**Liddell Battery and Bayswater Ancillary Works (SSD-8889679)  
Request for additional information**

I refer the Liddell Battery and Bayswater Ancillary Works (SSD-8889679) project. The Department requests that you provide the following figures for inclusion in the Department's Assessment Report and in draft conditions:

**Figure 1** The general layout of the development

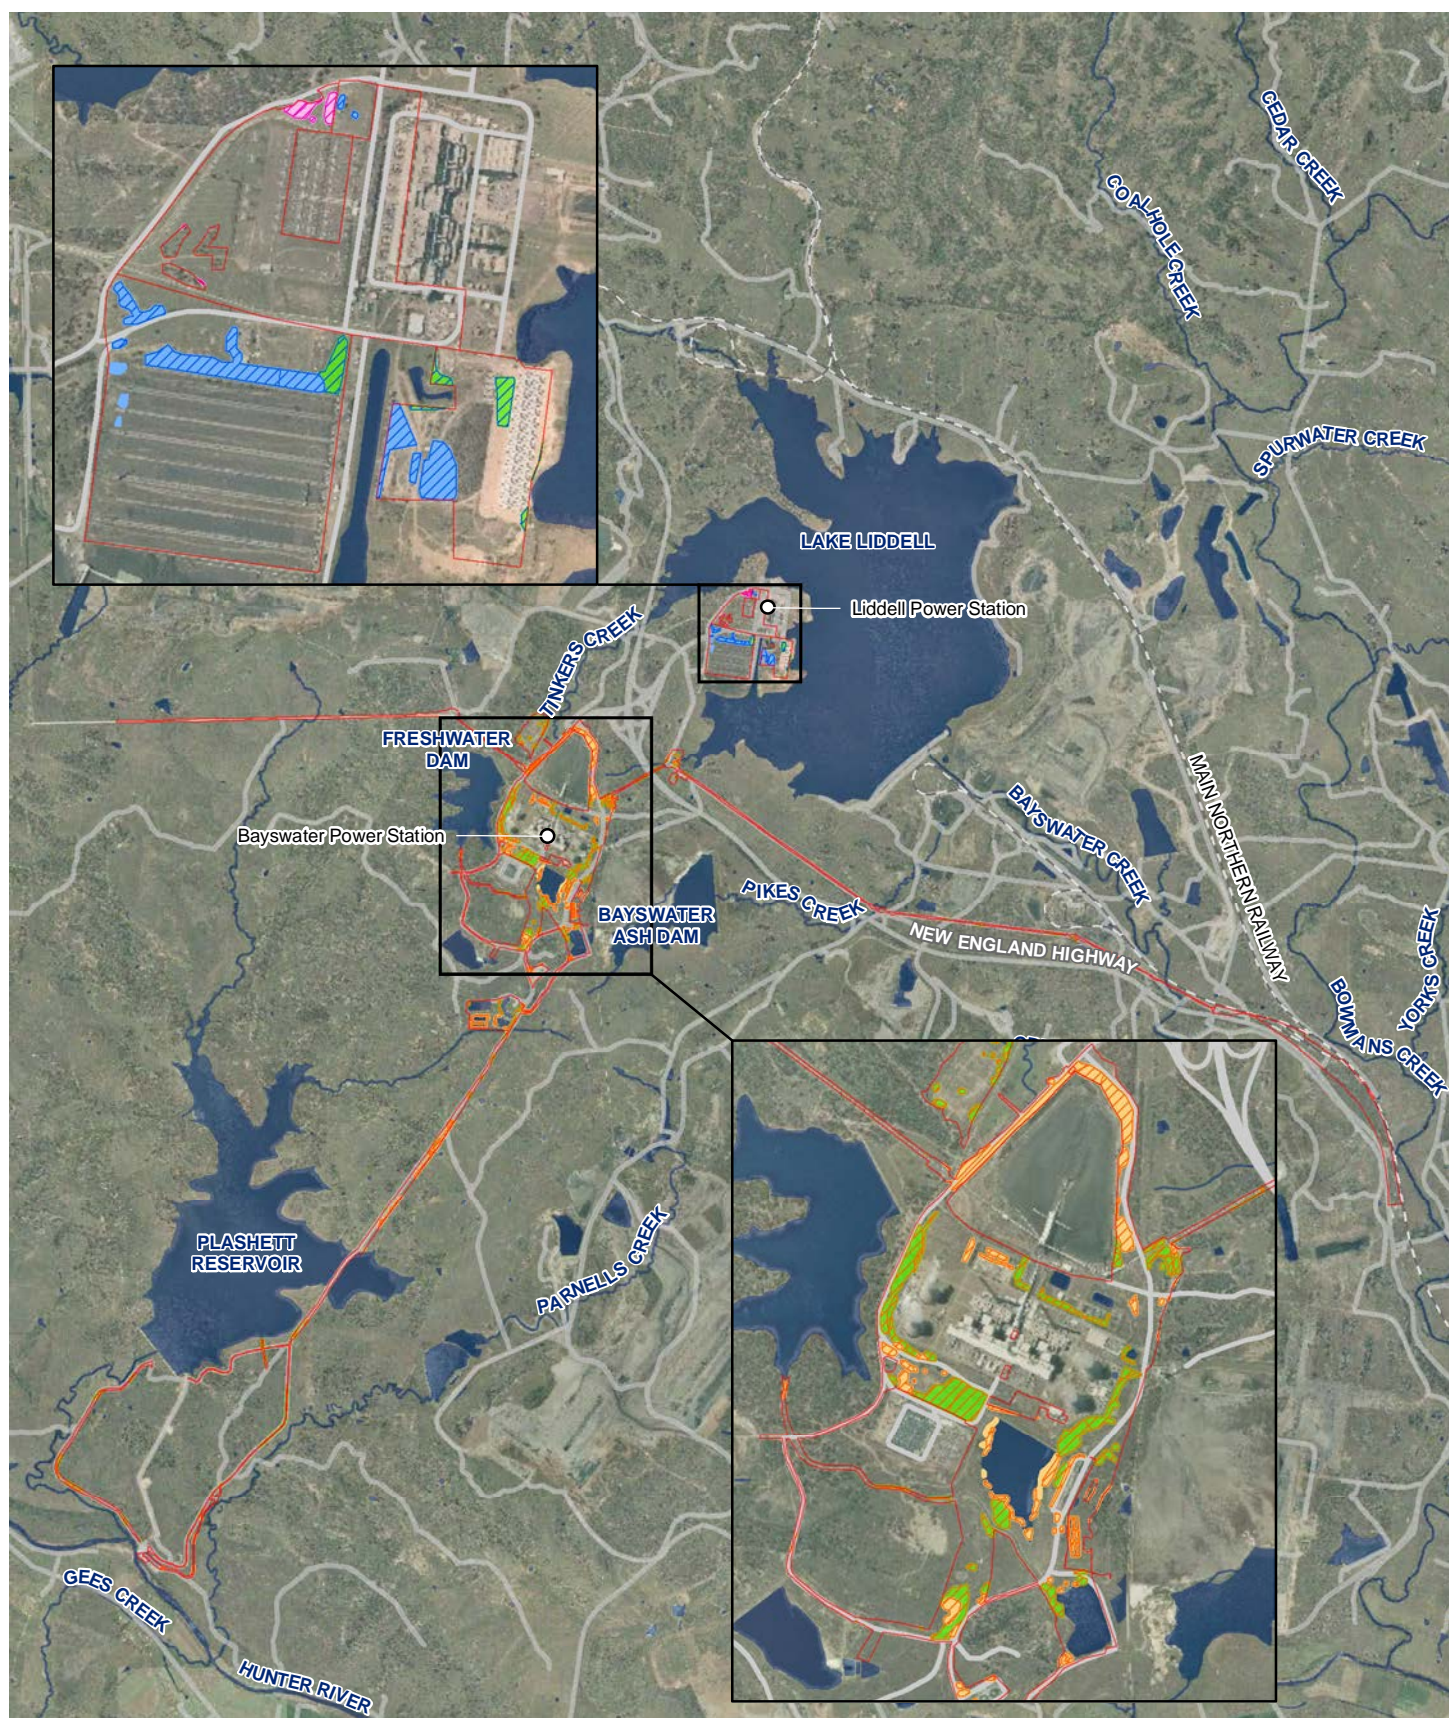
- Updated project overview figure of the amended project
- The general layout of the development, including:
  - A continuous red line outlining all areas subject to the approval (including battery, decoupling, Bayswater ancillary works and consolidated consents).
  - Shading identifying the four project areas as described above
  - Labelling limited to:
    - Liddell Power Station
    - Bayswater Power Station
    - New England Highway
    - Main Northern Line
    - Waterways
- Biodiversity offsets, including
  - Text and shading to identify the three offset stage areas.
  - Labelling consistent with the above (as visible in the figure)
- Native vegetation unlikely to be impacted, including
  - Shading identifying areas of native vegetation that are likely or unlikely to be cleared as per Table 14 of the BDAR
